Palmer Divide Lot Line Adjustment, VR-17-007

Please accept the following comments from El Paso County Public Health regarding the project referenced above:

# PALMER DIVIDE FILING NO. 1A

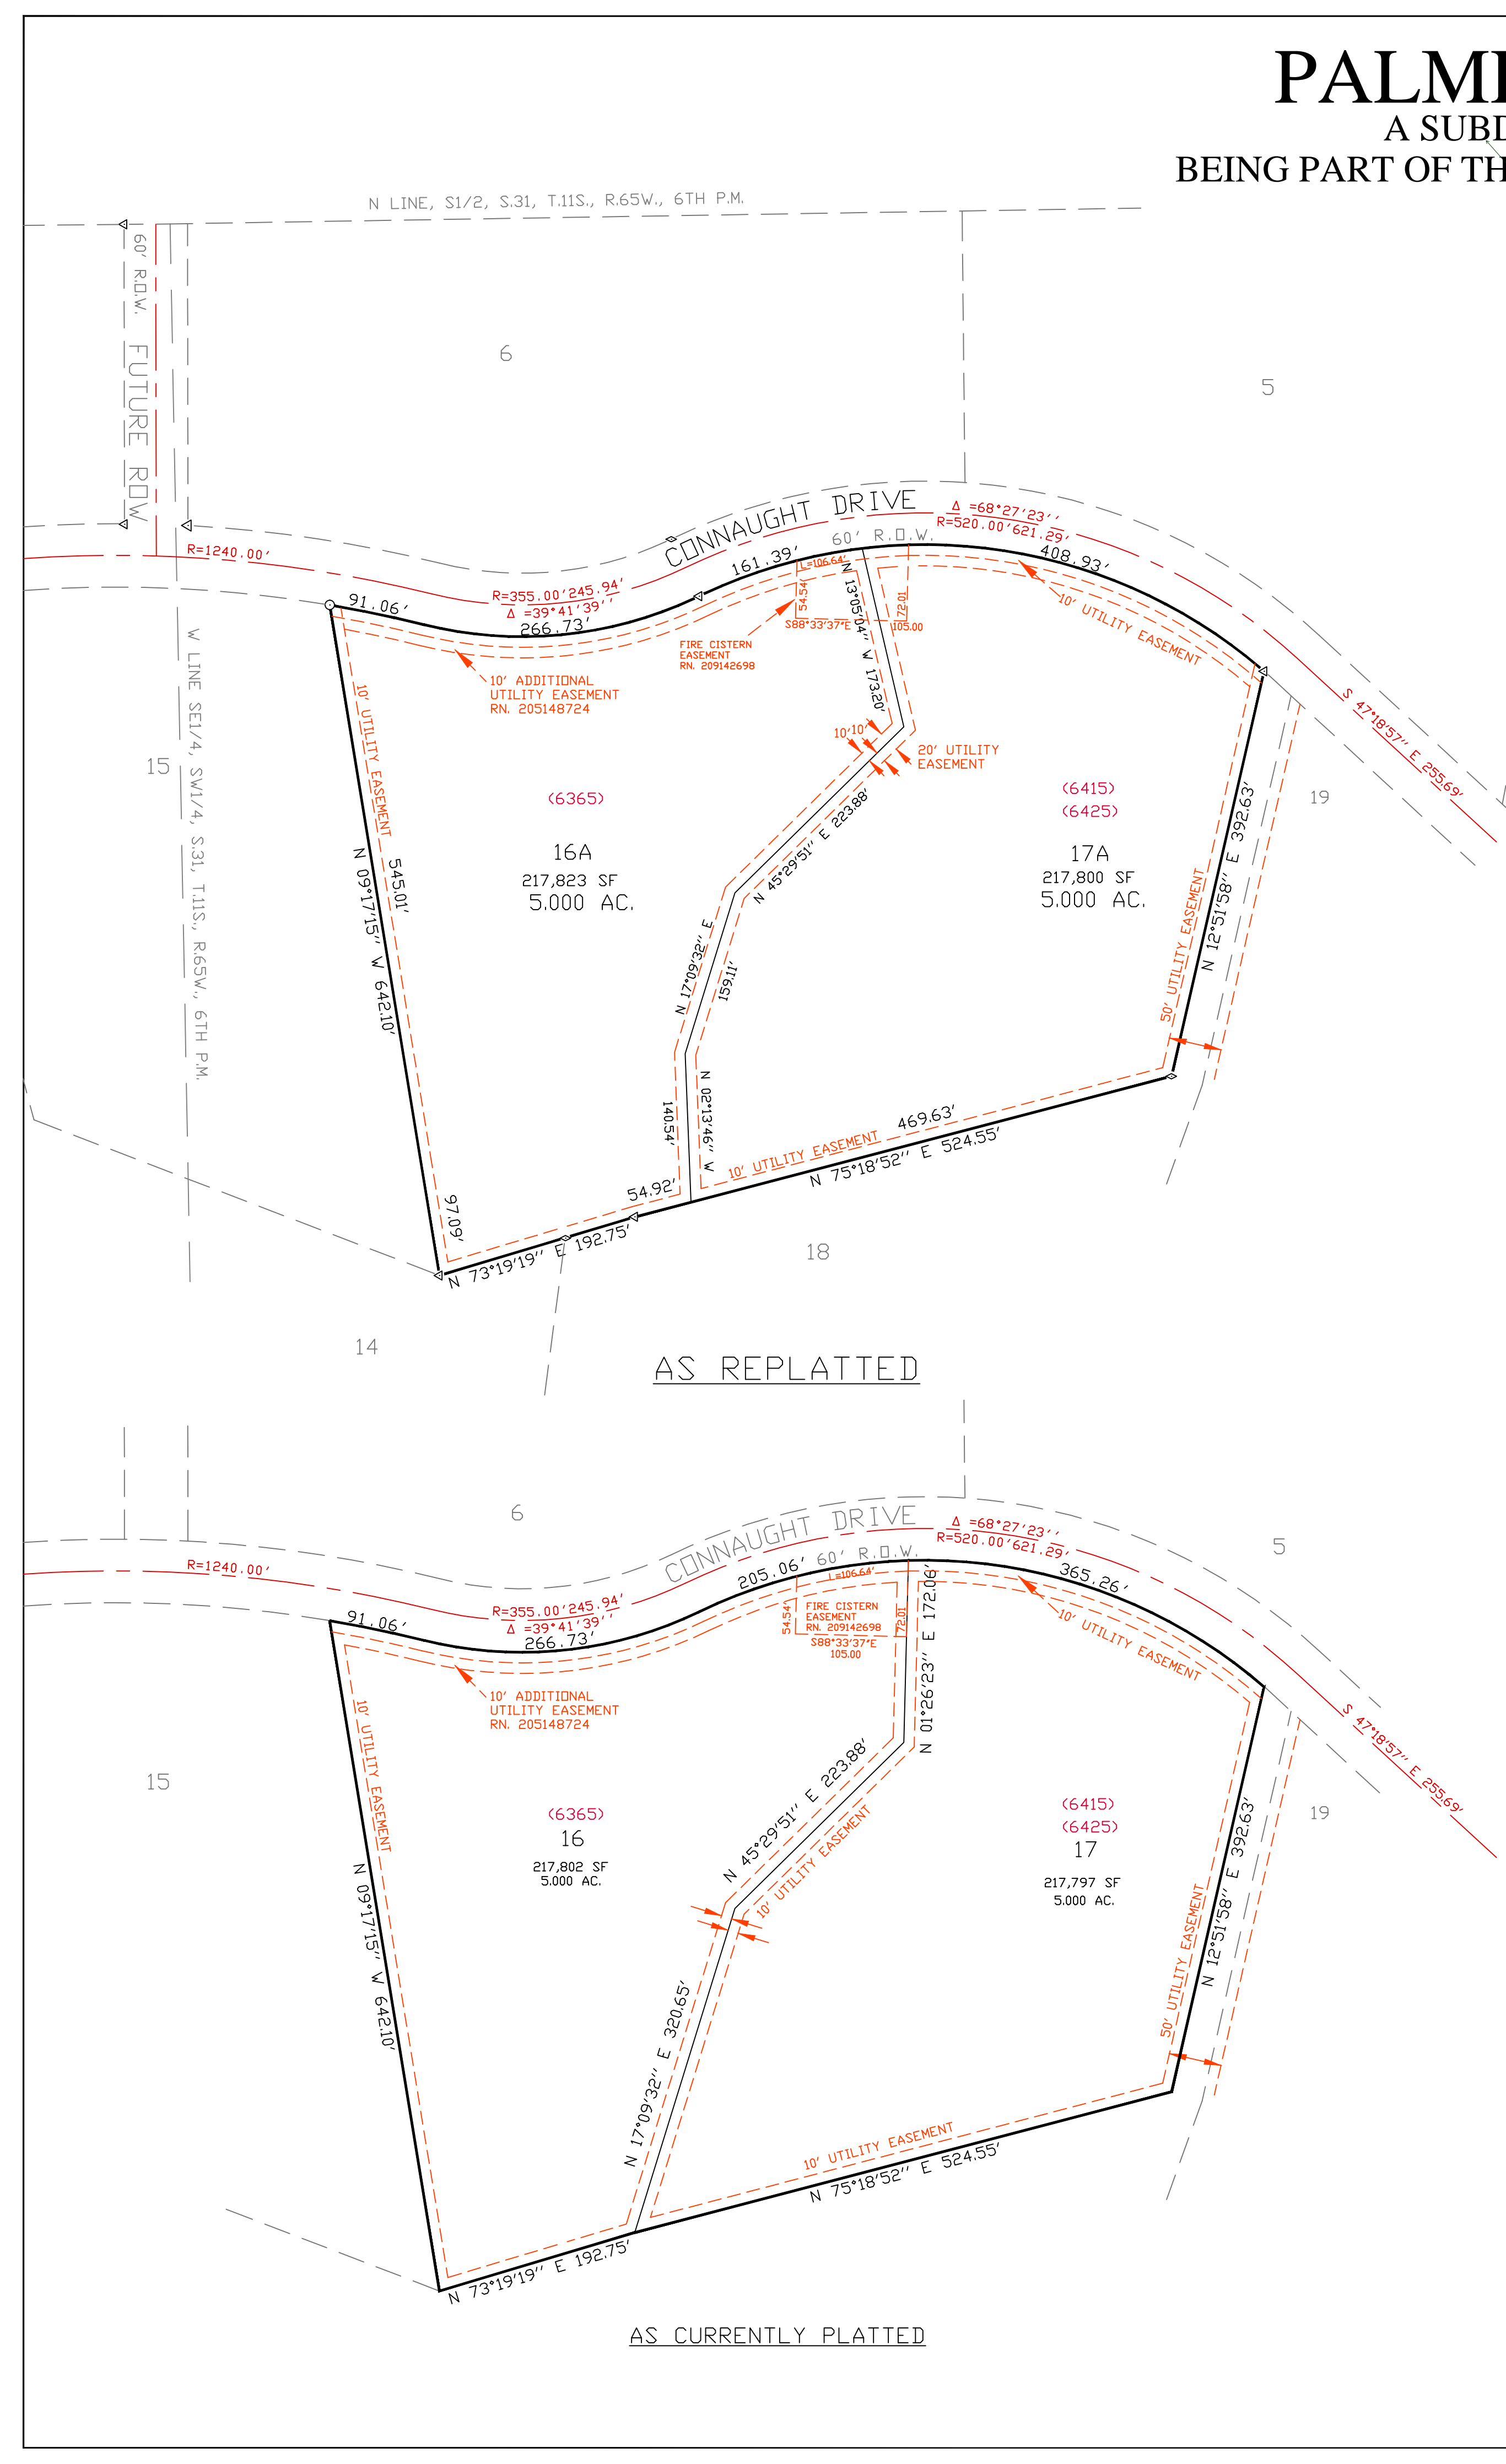
- El Paso County Public Health (ECPH) understands a new well will be required for the proposed lot 16A. Although the reason for the well replacement is not clear in the submittal, replacement may be associated with the existing well being located on the proposed adjacent lot 17A. Final disposition of this well shall be determined by the Colorado Division of Water Resources. Please be aware of the minimum horizontal setbacks the new well on proposed lot 16A must maintain from both interior and exterior onsite wastewater treatment system (OWTS) components.
- The lot line adjustment shall also satisfy the minimum setbacks of both existing OWTS components from the proposed new lot line adjustment. ECPH records for the two OWTS's are available if needed to verify OWTS component locations.
